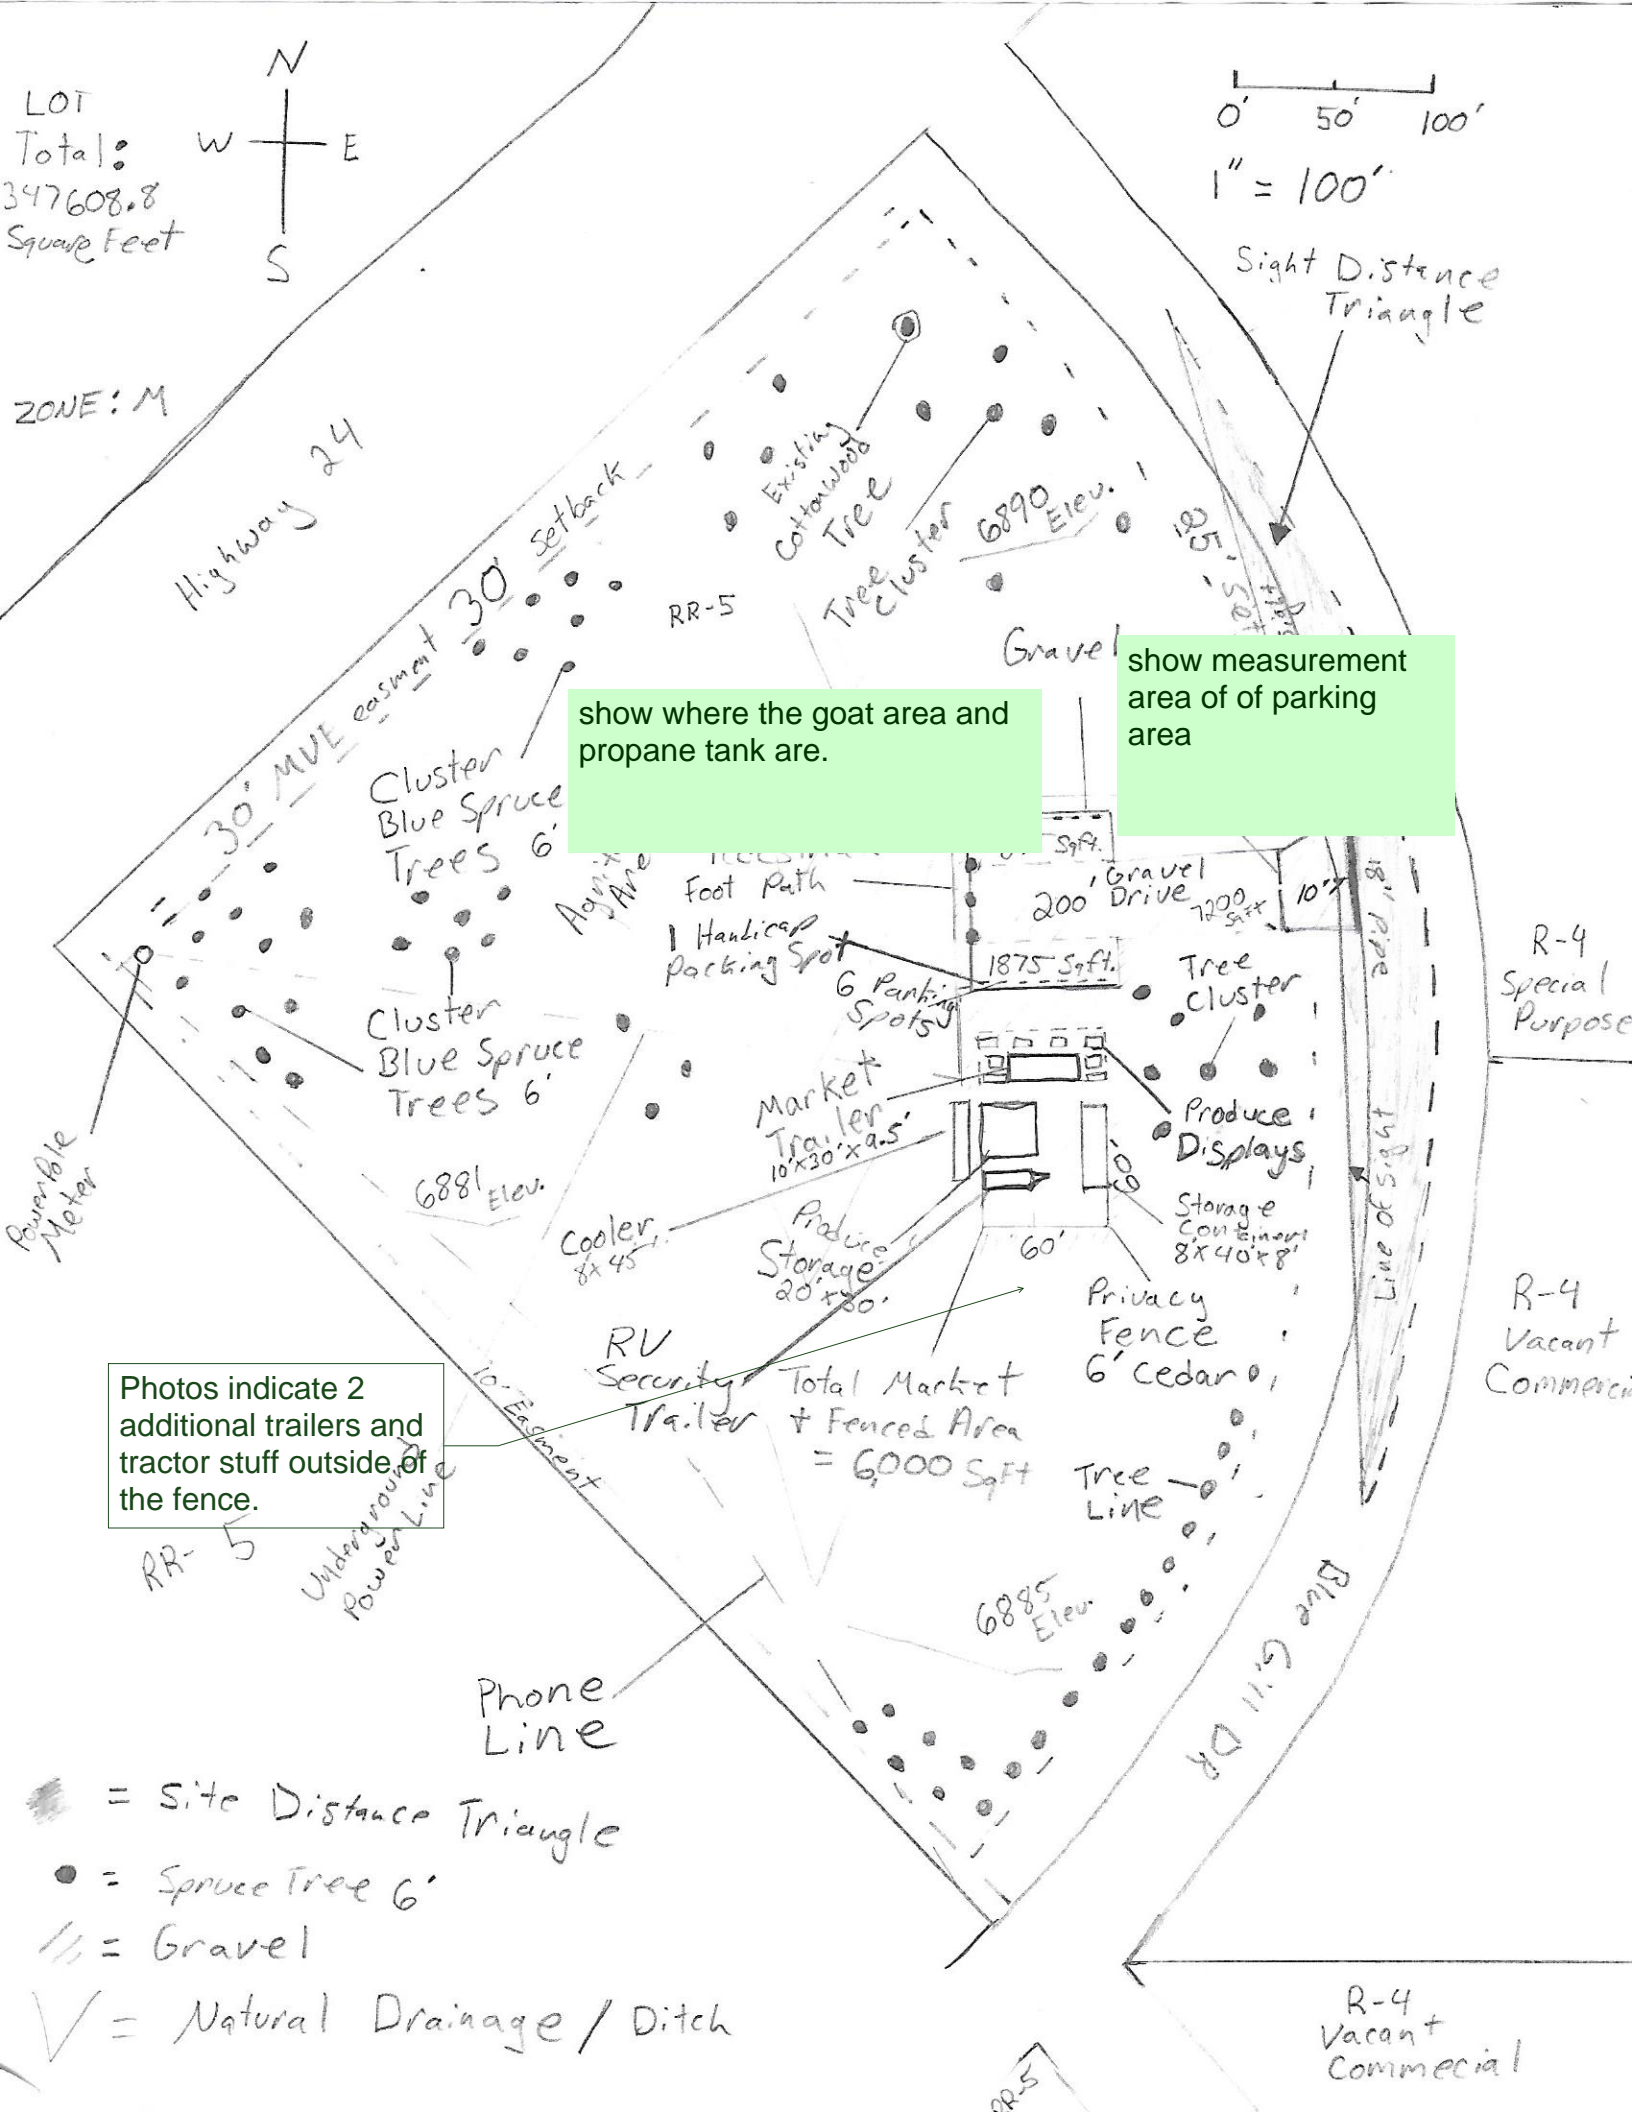
1. Draw the line-of-sight (blue line and label) Per engineering criteria manual figure 2-23. Contact the review engineer if you need clarification.

2. Hatch in the area (highlighted in yellow) between the centerline of the road and the line of sight and label as sight distance triangle.

3. Add the following note:
"Any object within the sight distance triangle more than 30 inch above the flowline elevation of the adjacent roadway shall constitute a sight obstruction, and shall be removed or lowered."

Revise driveway width. Maximum allowed is 40'. The applicant will need to obtain a driveway access permit. The inspector will verify the entering sight distance for the driveway location meets criteria.

The Letter of Intent states 30-80 customers per day, you will need to justify how you will meet this demand with 14 parking spots in the letter of intent. You must also account for handicap spots, 1 will be required if total spots is 25 or fewer.

Define what will occur in the "Agritainment Area"
